From: Carmichael Ian <Ian.Carmichael@thamesvalley.pnn.police.uk>
Sent: 13 March 2020 13:33
To: Caroline Ford
Cc: Planning
Subject: Planning ref: 20/00293/OUT. Bicester Gateway Business Park Wendlebury Rd Chesterton.

Planning ref: 20/00293/OUT. Bicester Gateway Business Park Wendlebury Rd Chesterton.

Crime Prevention Design Advisor | Oxfordshire | Local Policing | Thames Valley Police

Figure 11: Indicative Masterplan

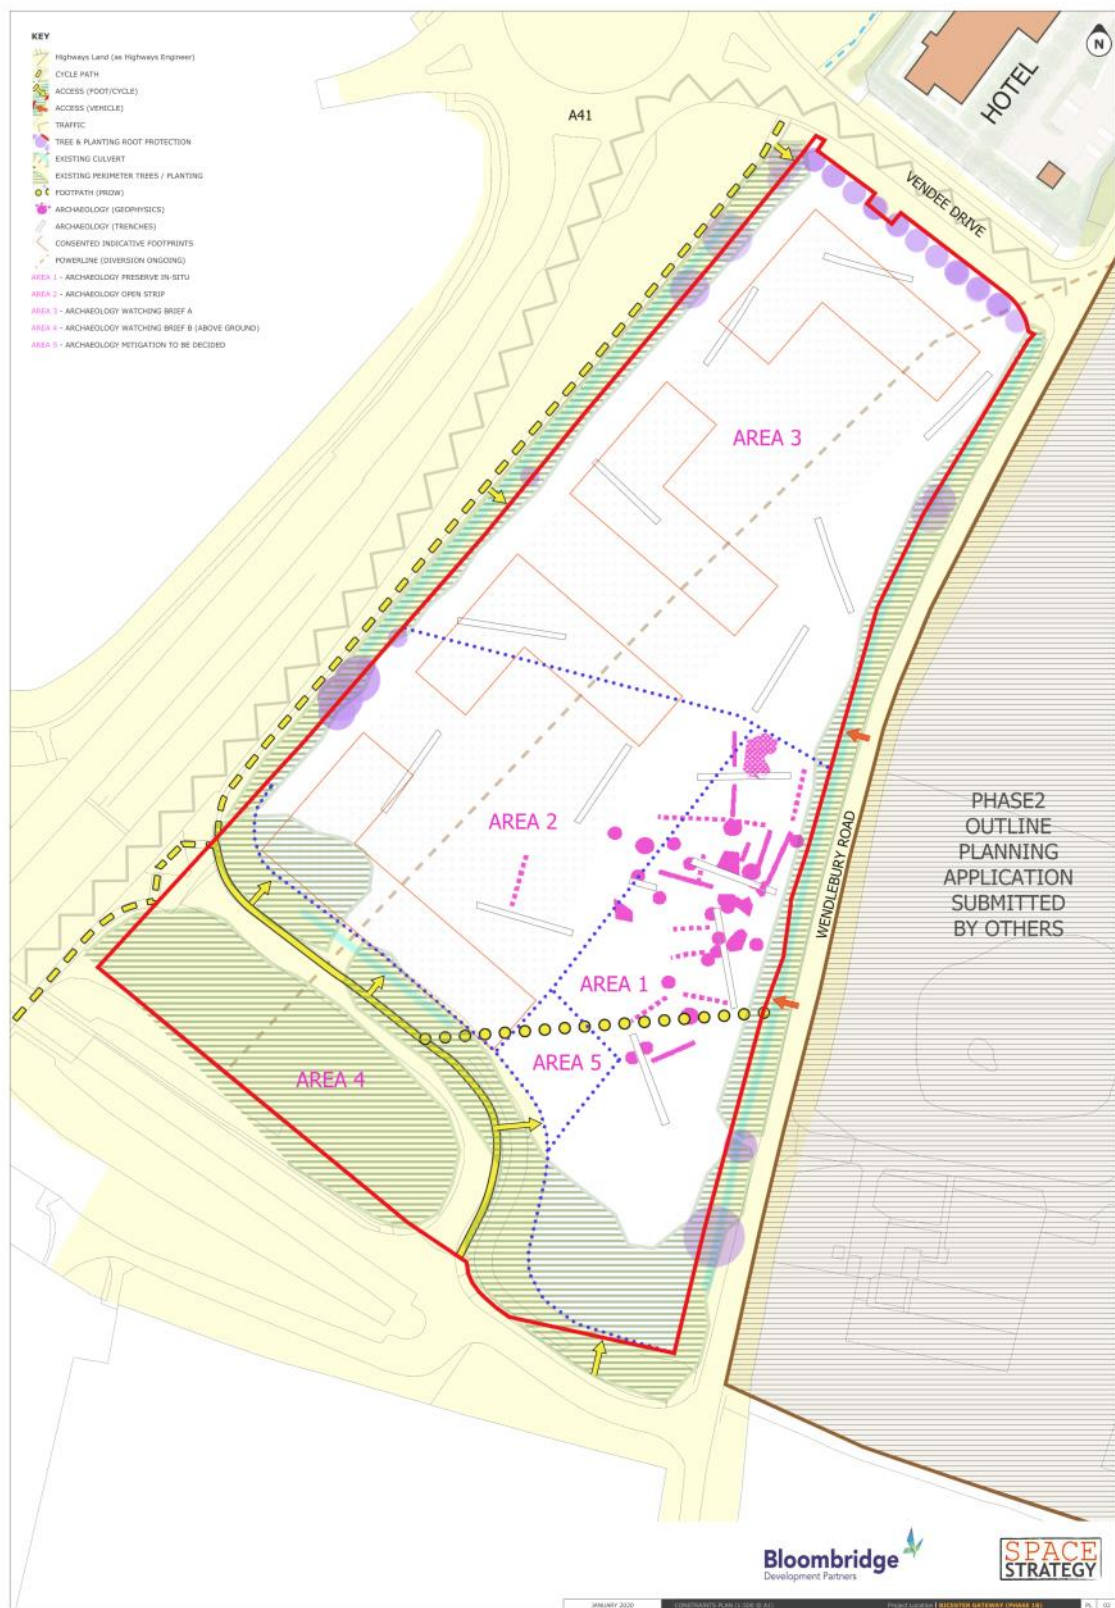
- I consider the layout to be excessively permeable. There are several segregated foot/cycle ways and access points that may attract crime/anti-social behaviour (ASB), aid criminal search behaviour and provide escape

routes for offenders. All routes should lead directly to where people want to go and serve a defined purpose. Permeability for permeability's sake should be avoided.

- The large parking area at the southern end of the site concerns me. If this is intended for residents of the flat blocks then it is likely to be poorly overlooked and too remote. This, in turn will provide opportunities for vehicle crime and potentially create parking issues across the site as and when residents decide they do not want to use the facility because of its vulnerabilities. I recommend that the parking strategy be reviewed to provide a more appropriate location.
